### **Final Report - Corrections Required** **Application No. ANEX-24-0007**

**Description : Matrix Design Group on behalf of Colorado Springs Equities LLC is submitting a serial annexation petition for seven parcels and Land Use Plan/Rezoning exhibit for a portion of the subdivision known as Rock Creek Mesa.**

**Document Filename : 224.023-LEGAL-RCM ANNEX 7.pdf**

ROCK CREEK MESA ADDITION NO. 7

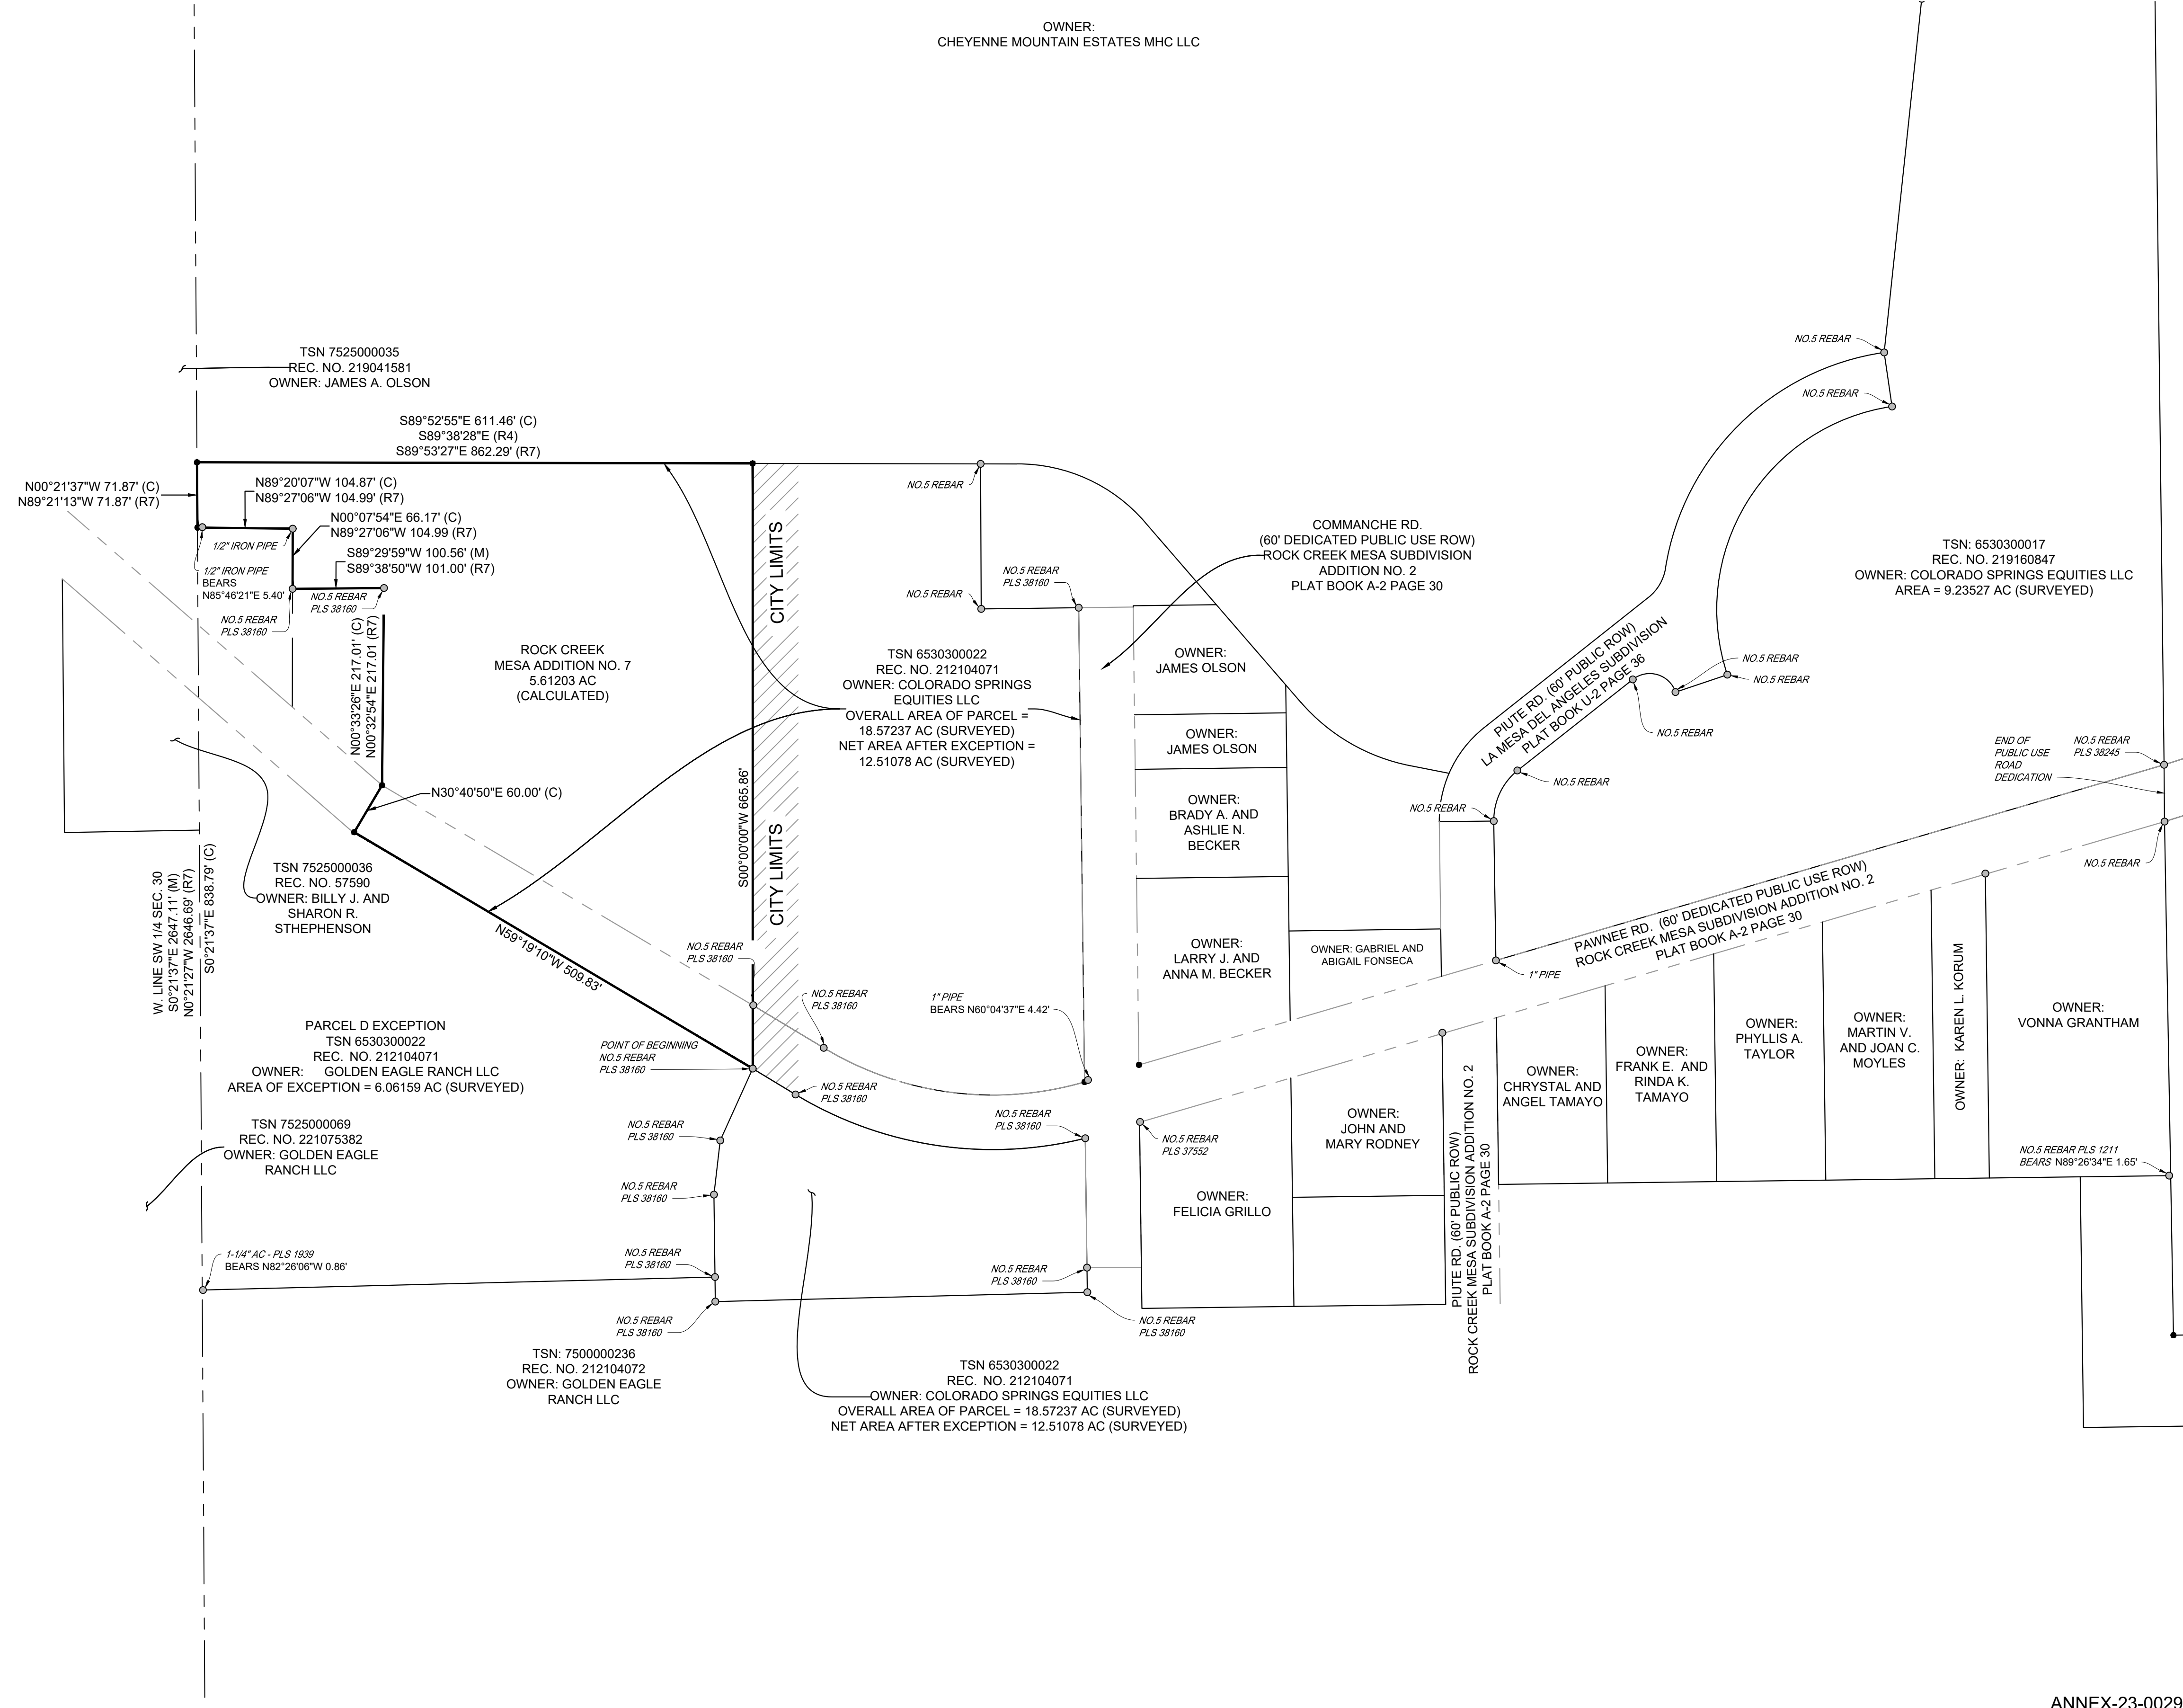
<b>Comment ID</b>	<b>Page Reference</b>	<b>Reviewer : Department</b>	<b>Review Comments</b>
17	1	Gabe Sevigny : Planning	Be sure that any changes on the Annexation Plat are reflected here and vice versa
31	1	Cory Sharp : Planning	Please revise exhibit A to: Rock Creek Mesa Addition No. 7
32	1	Cory Sharp : Planning	Please add the area at the end of the legal description
